From: Martyn White
Sent: 13 August 2019 13:50
To: Planning.Responses <Planning.Responses@arun.gov.uk>
Cc: Amber Willard <Amber.Willard@arun.gov.uk>
Subject: AW/184/19/HH & AW/185/19/L

AW/184/19/HH & AW/185/19/L

149 Barrack Lane is a Grade II Listed Building. It was previously part of a larger house but was created when that building was subdivided into two smaller properties at some point in the C.20.

SITE PLAN 1:100

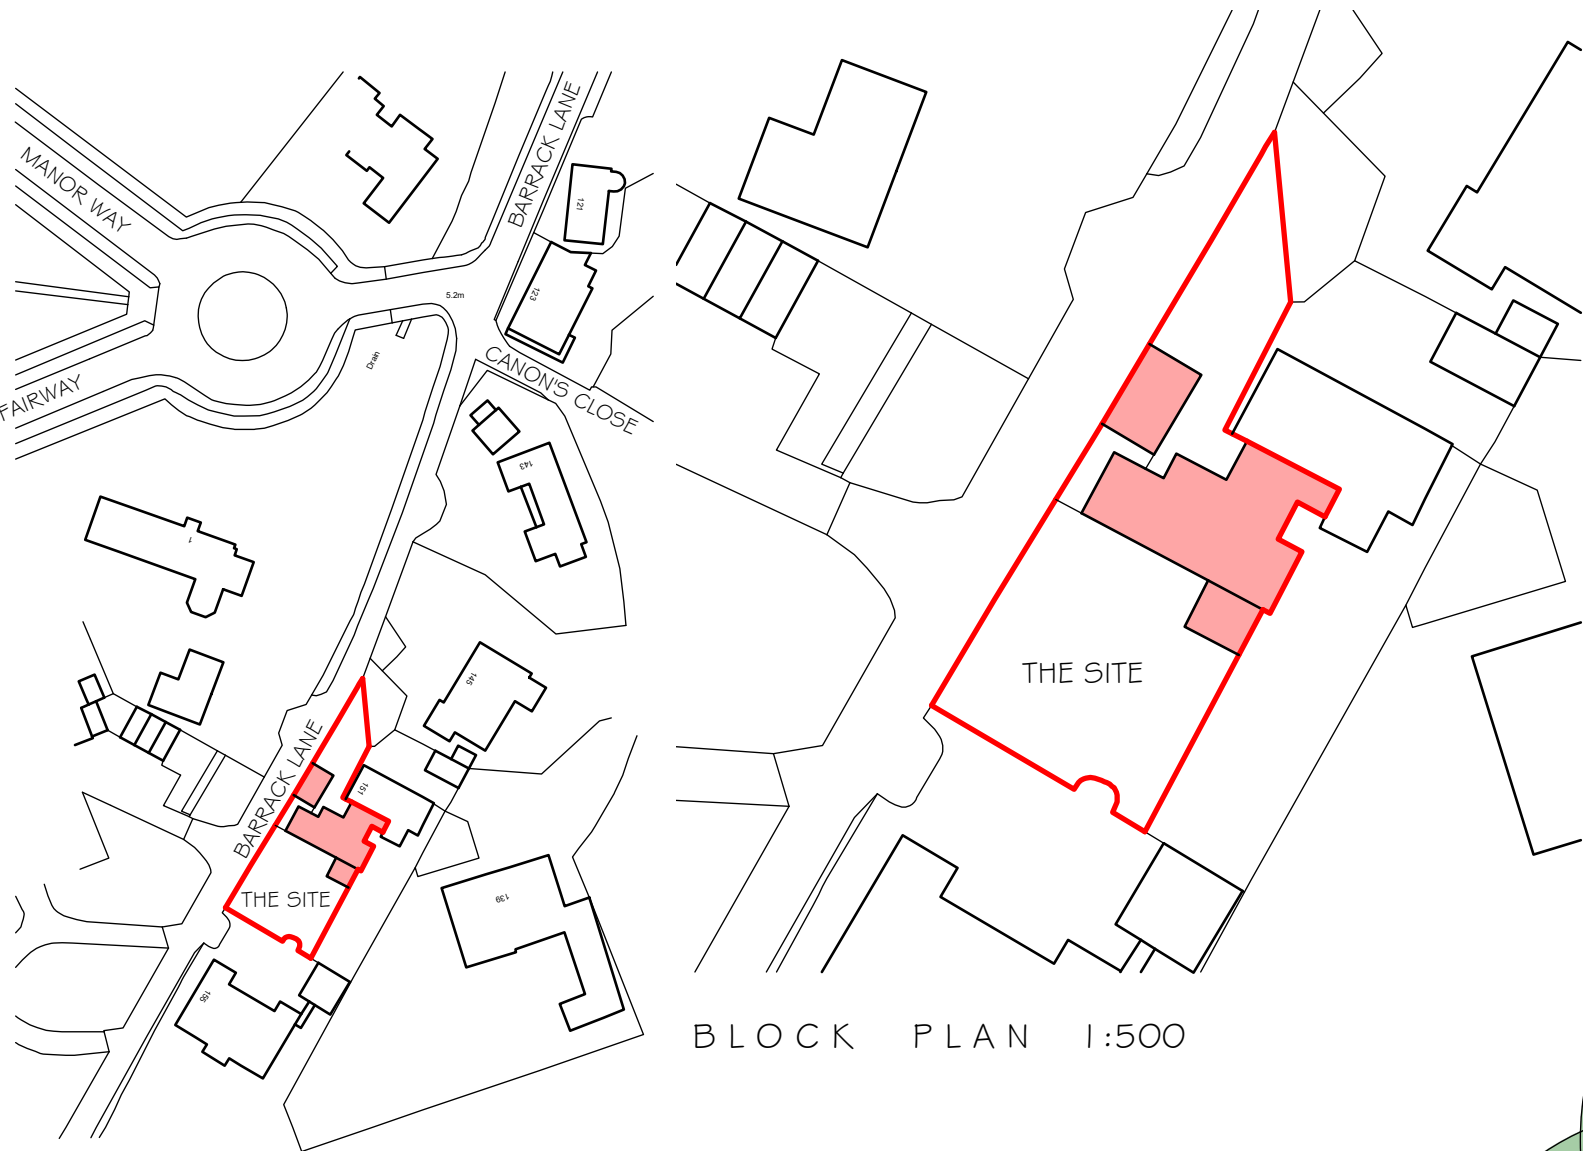
The two extensions to the building are small scale in appearance, with the proposed covered passage/storage area utilising an existing area between the house and the existing boundary wall. The flat roofed element should be subservient to the listed building and not visible from the carriageway. It is suggested that the roof should not overhang the existing wall in any way.

It will be important to ensure that this element of the works will not harm the boundary wall which is not only part of the curtilage of the listed building, but also an important part of the street-scene. You may wish to request details of how the wall will be protected as part of the proposals.

Likewise, the proposed porch extension appears to be small in scale and reflects the established character of the building. The concept of a pitched roof to the existing garage is positive as it will ensure that it is better reflects the character of the listed building.

Works which replace the modern glazing system on the conservatory roof will be an enhancement to the building. Works to the rough cast render should match existing, including the existing colour and texture. It is also considered that the works to windows WF05. 06 07 and 08 and DG08 will have a neutral impact, subject to details.

The new out building is located to the rear of the garden, and adjacent to a neighbouring garden structure. It is considered that its location, design and the fact that it screens a neighbouring structure means that it is acceptable.
